Re: Luminato Condominium, LLC  
Proposed Minor Amendment to Approved Site Plan

## **LUMINATO CONDOMINIUMS**

Landscape proposed additional work: 8.9.17

C1.2

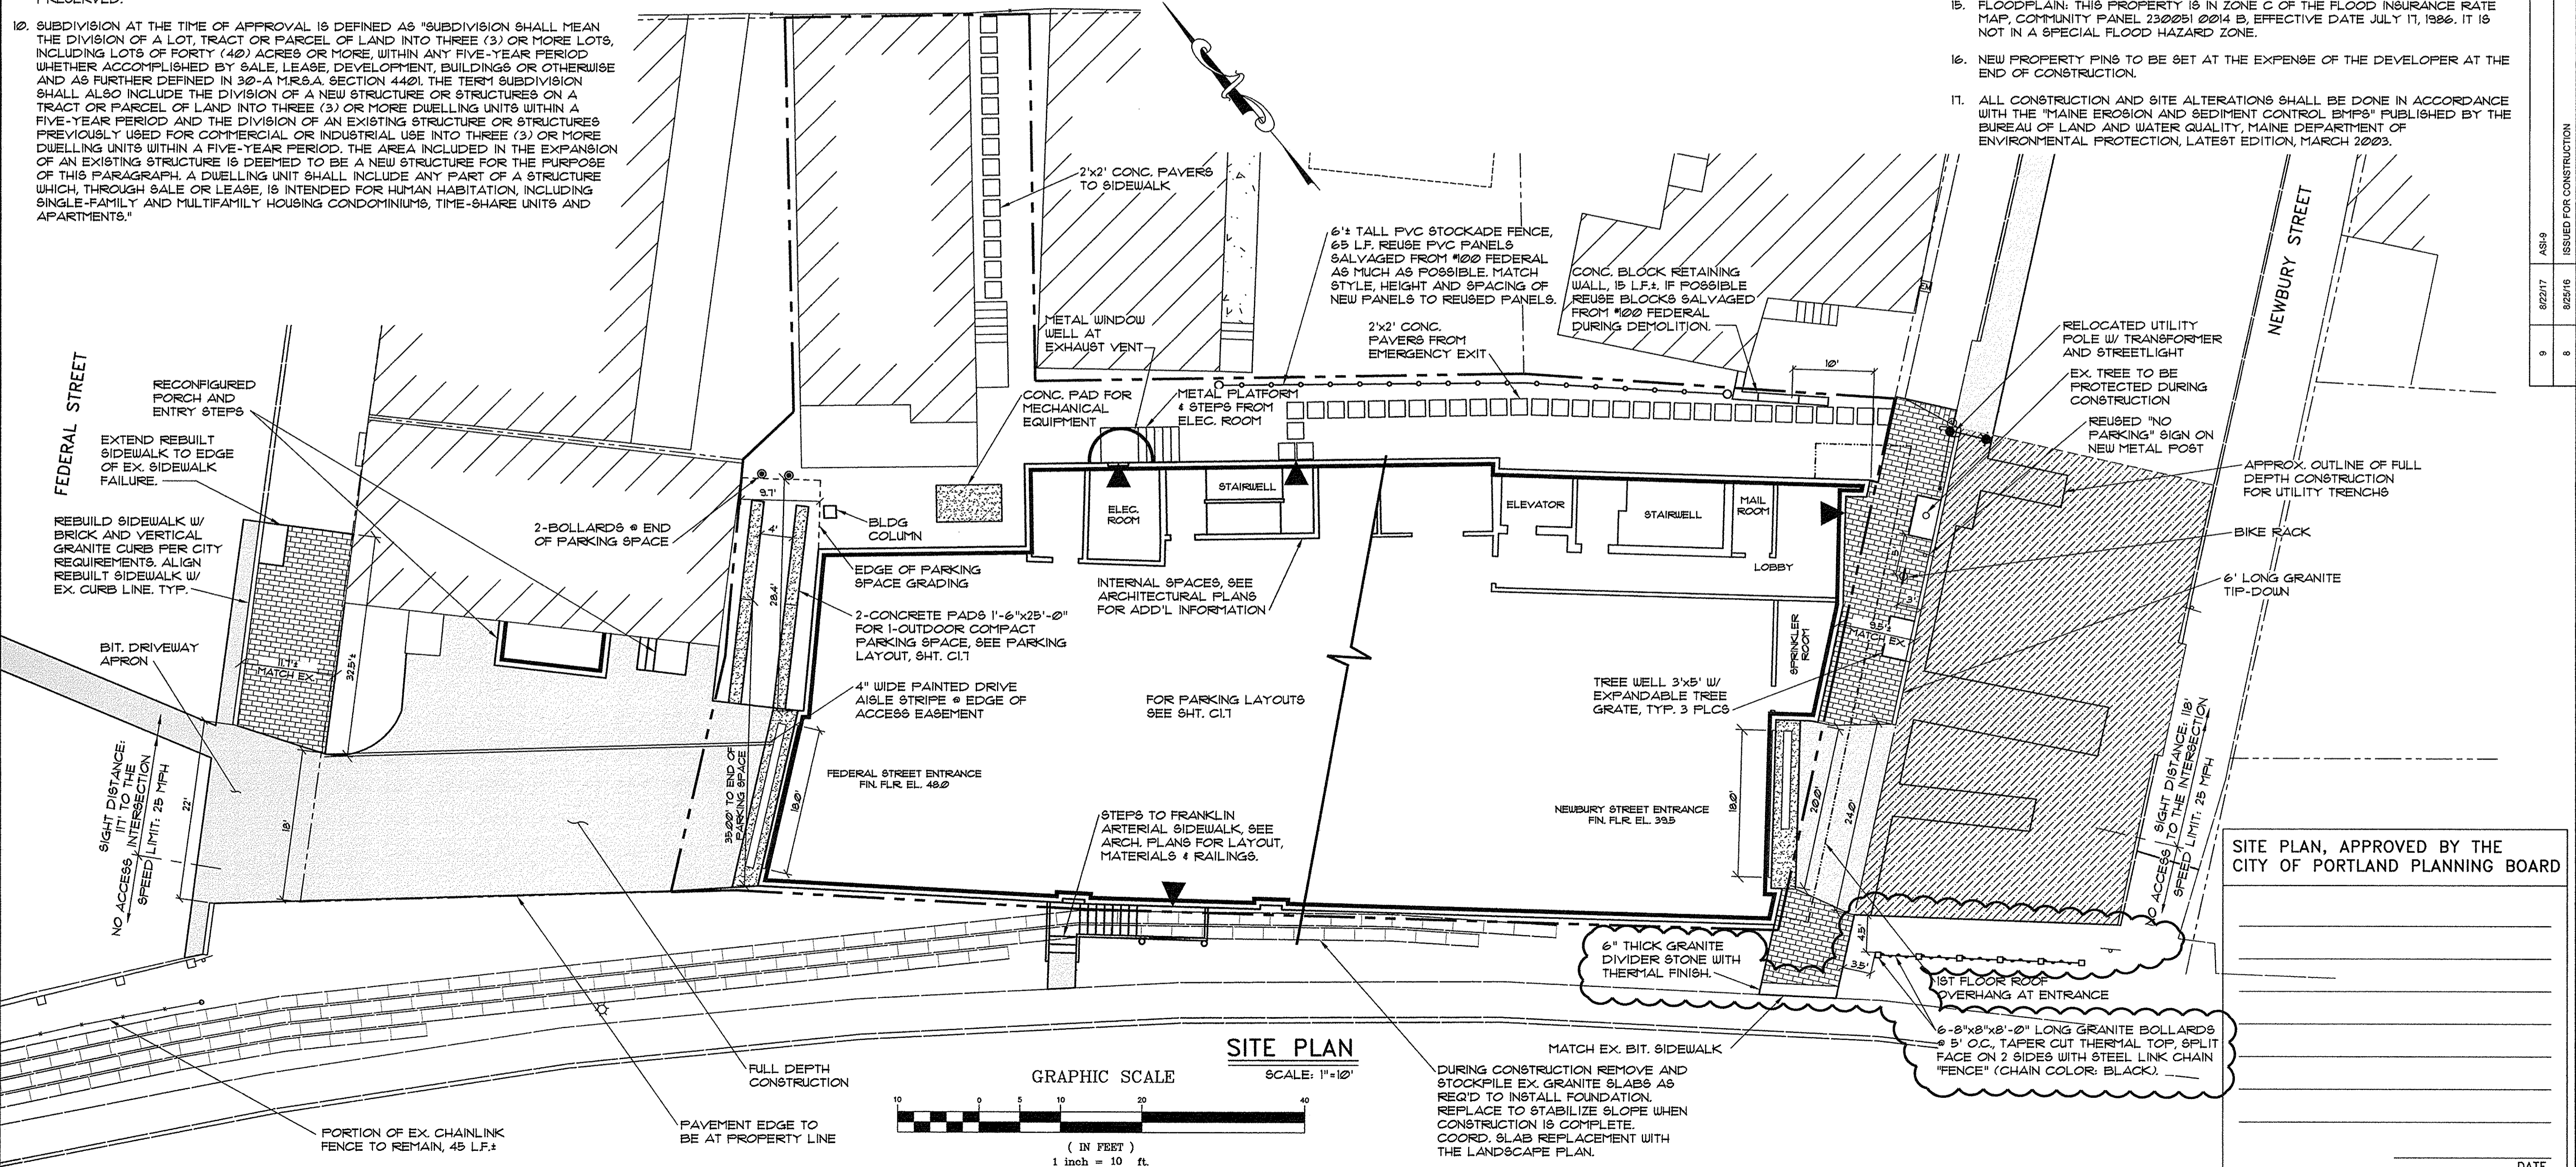
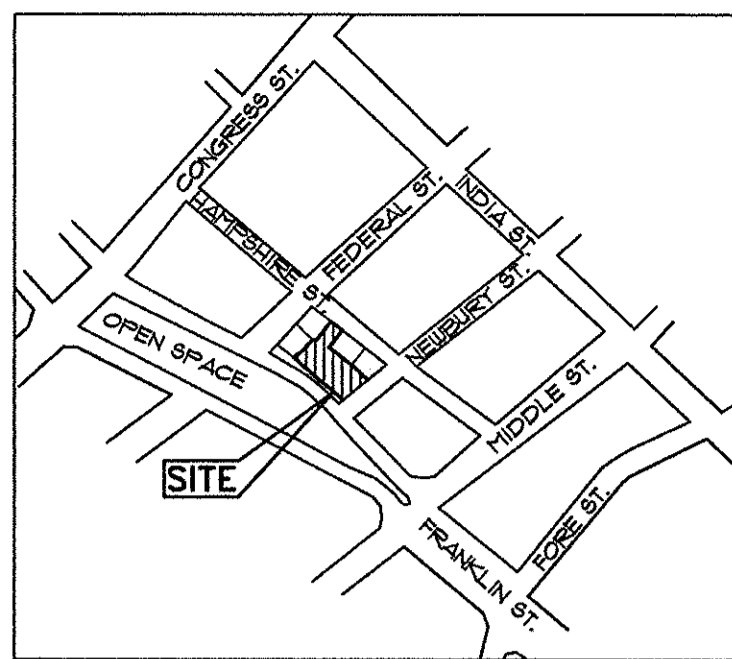
I am writing to make application for a minor amendment to the approved Site Plan for Luminato Condominium, LLC. We are requesting permission to extend the landscaping planned along Franklin Street to include land owned by the City of Portland at the end of Newbury Street where it comes to a dead end at 169 Newbury Street, in front of Luminato.

The plan would add hardscaping at the end of the street, a connection between the city sidewalk on Newbury Street and the city sidewalk on Franklin Street, and additional plantings as described more fully by Landscape Architect Anthony Muench in the attached document.

Pinkham & Greer has revised plan sheets C1.2, C1.4, and C1.6 of the approved plan set and uploaded them to the project's E-Plan account. The memo described above, as well as .pdf copies of the named plans are also attached here for ease of reference.

Extend landscaping from the S.E. Corner of the New building along the north east side of Franklin Street Arterial for approximately 50'. The width of the area is from 12' to 14' wide.

1. [6] granite bollards , 8"x8"x8' installed to 40" ht. Above grade'  
Bollards are 5' o.c. with and attached chain between each one.  
Each link will be 3" long made with ¼ "dia. Steel material.
2. Brick sidewalk paving specify as Standard City of Portland brick on bituminous base.  
Aprox. 80 s.f..
3. One granite edge stone 18" x 6" x8' as a divider between the new brick walk connector and the existing bituminous walk along Franklin Street.

1. Install six [6] Compact Red Twig Dogwood, parallel to the bollard alignment.
2. Install two [2] Bosnian Pine at the eastern corner of the planting bed.
3. Install 64 daylilies as shown on the plant list.
- 4.

Adjacent areas shown on plan will be loamed and seeded as per the original specifications.
